**Consultation Response from KC,
Highways Development Management**

2023/93342 Moss View, Burnlee Road, Holmfirth, HD9 2LE

Outline application for demolition of existing dwelling and garage and erection of two detached dwellings with attached garages

Responding Ref: 3-36-25.

SITE PLAN (1:200)

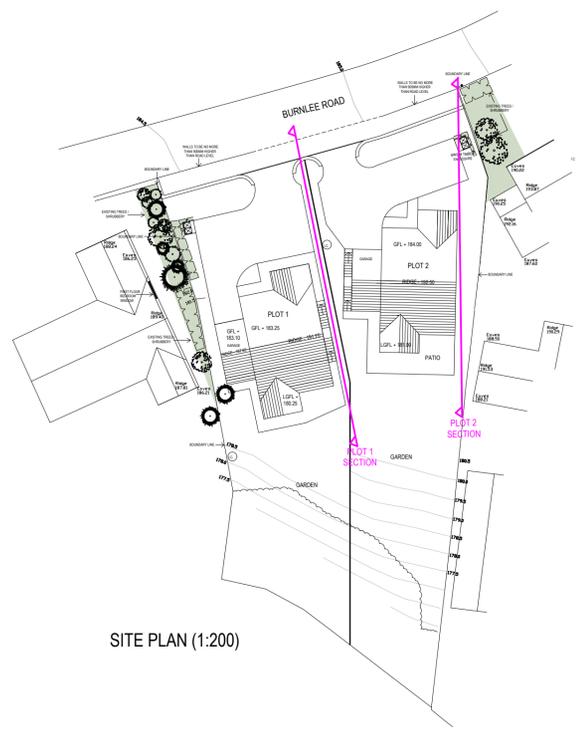
The proposed site plan shows 2 detached houses with attached garages and driveways with internal turning spaces and bin storage to the front. The walls to the site frontage are shown to be 0.9m high to improve visibility.

Highways Development Management have no objection to these proposals in principle but would recommend that a 2.0m wide footway is provided to the full site frontage to improve pedestrian facilities in the locality and ensure that acceptable sight lines are retained from the proposed access onto Burnlee Road.
